**RE: SSD 9601 BRICKWORKS PLANT 2 UPGRADE, 780 WALLGROVE ROAD, HORSLEY PARK, NSW 2175
FAIRFIELD CITY COUNCIL RESPONSE TO SUBMISSIONS**

We have reviewed your correspondence dated 28 February 2020 and on behalf of our client Brickworks Ltd hereby provide the following response to your Item D – On-Site Detention Design.

Drawing No.				
													Project No.				
													Issue				
													DAC021				
													18-577				
													D				
													A1

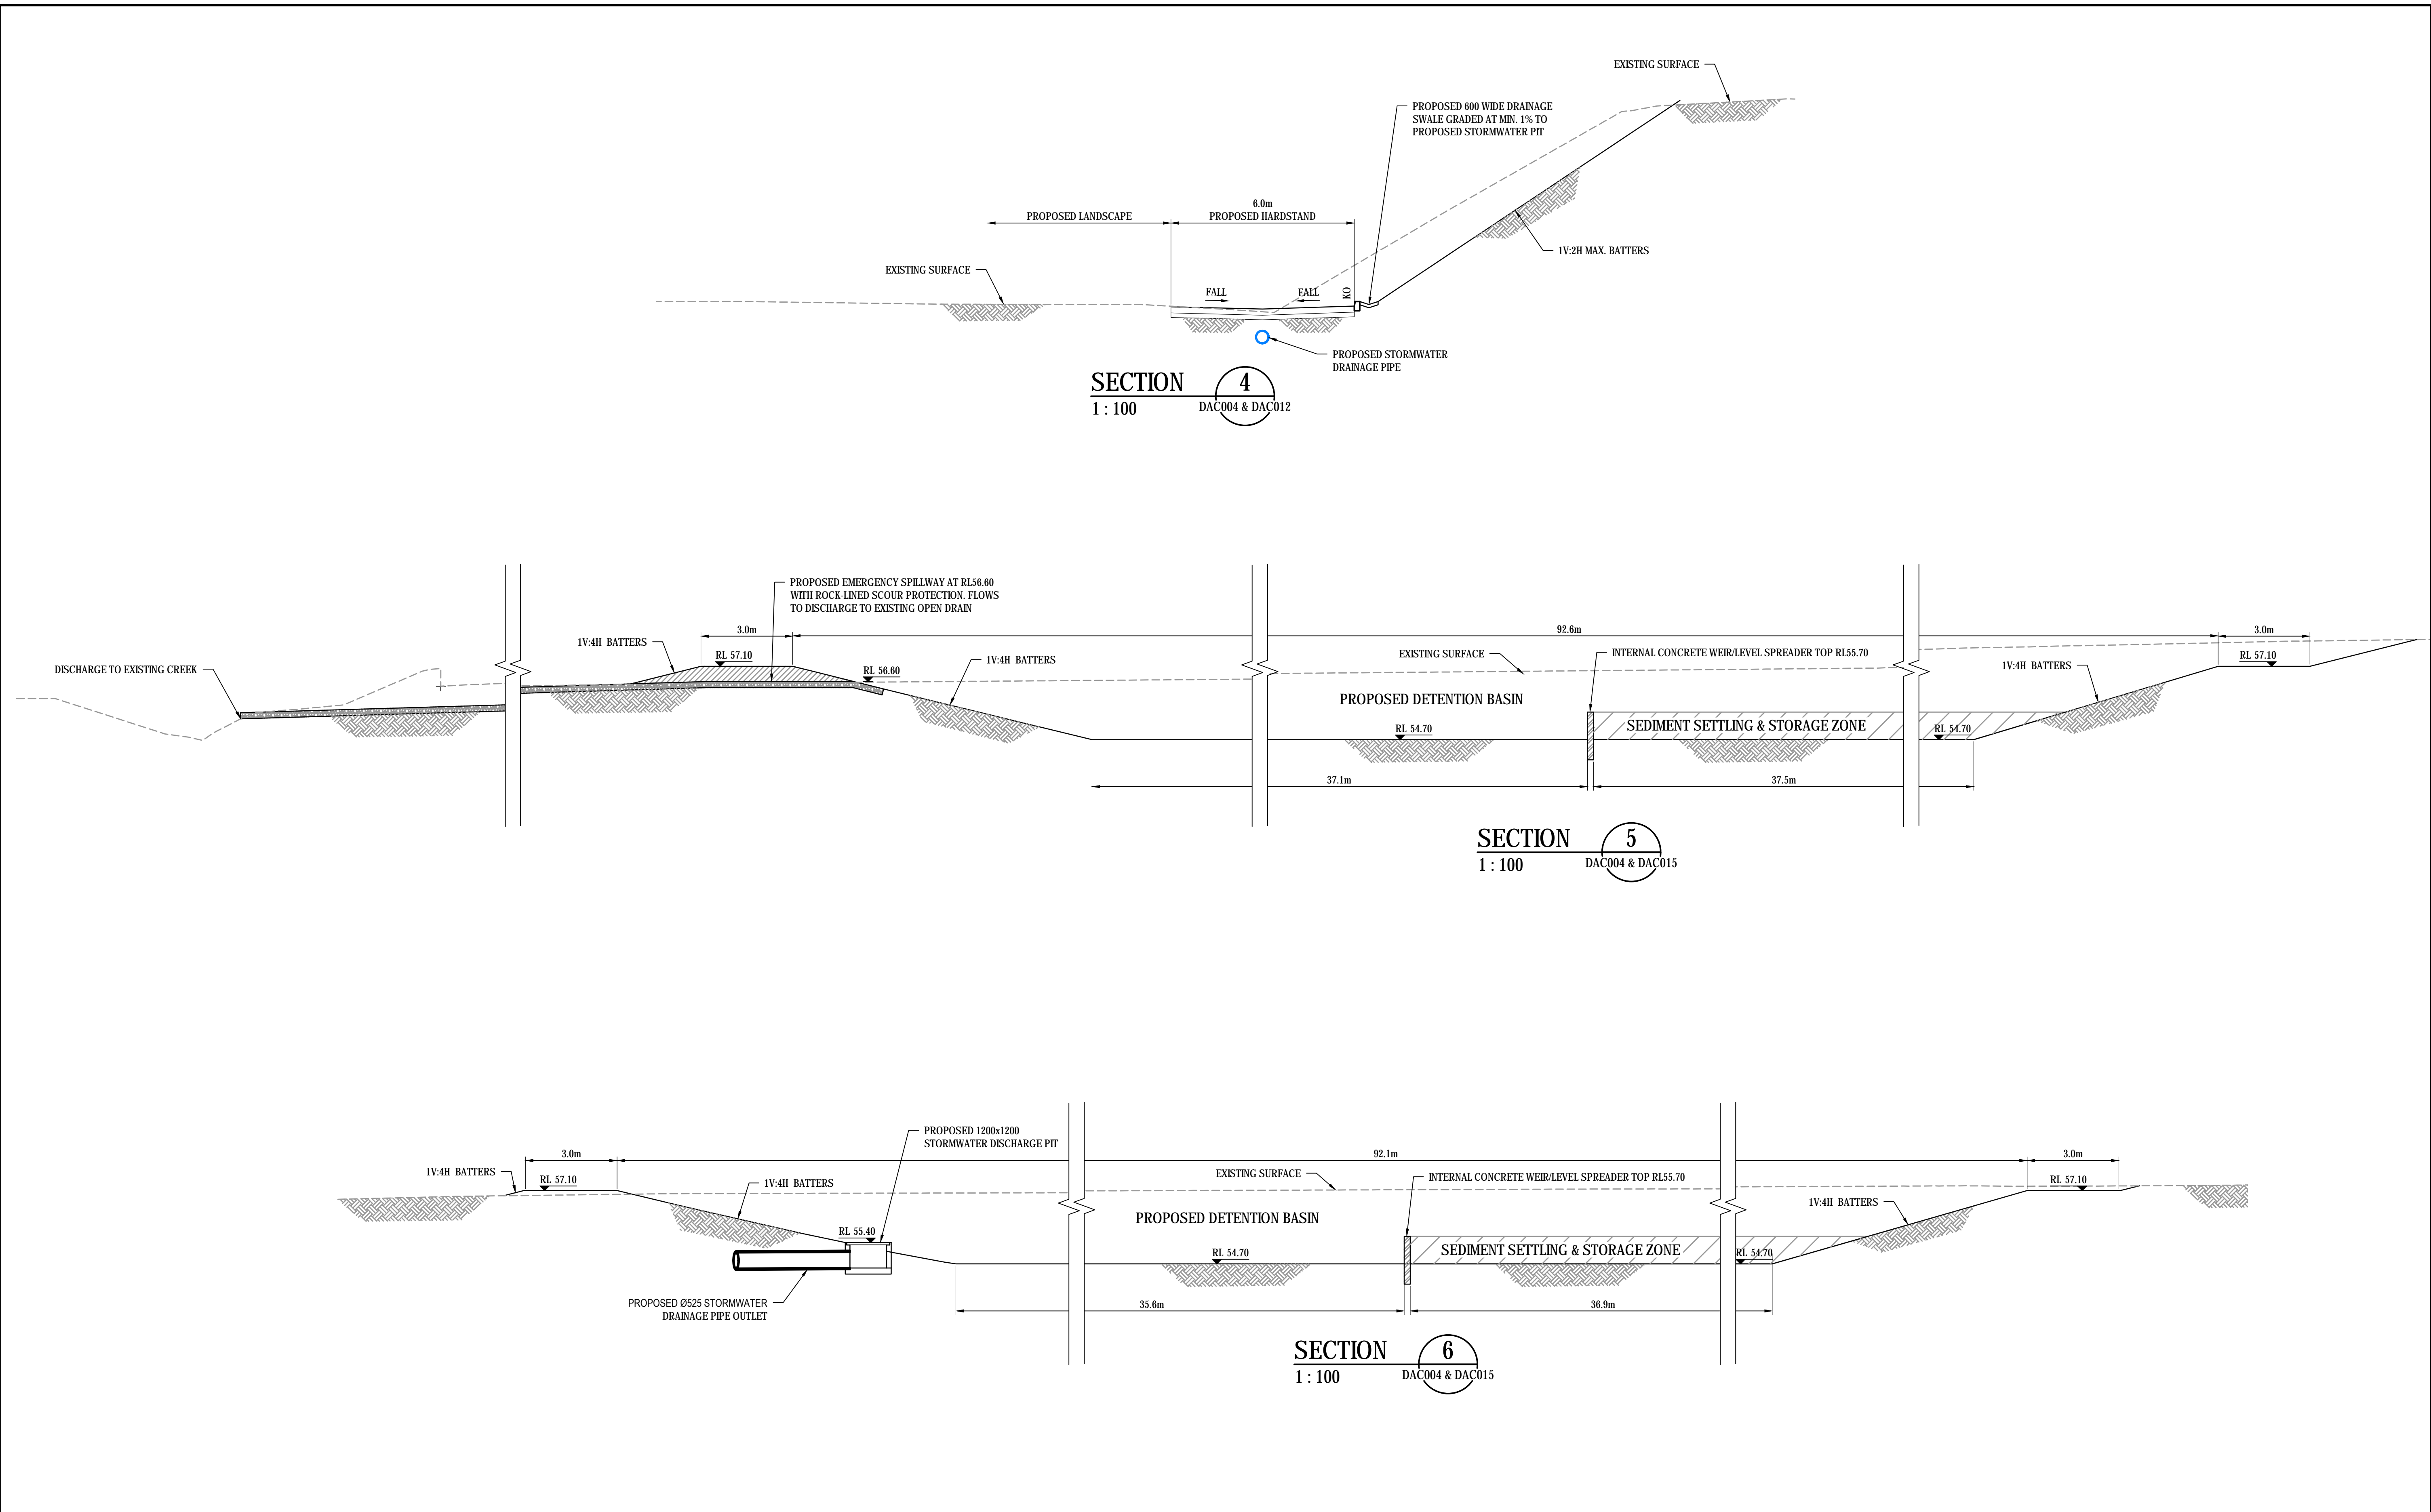
Please refer to the detailed sections of the basin shown on AT&L Drawings DAC021 and DAC022, including one through the outlet location to Eastern Creek. Refer plan DAC015 for section locations. Please also refer to Sections 3.4 and 3.5 in AT&L's updated *Soil & Water Management Plan and Civil Engineering Design Report (REP001-03-18-577)* for a detailed description and calculations relating to stormwater quantity and quality treatment features.
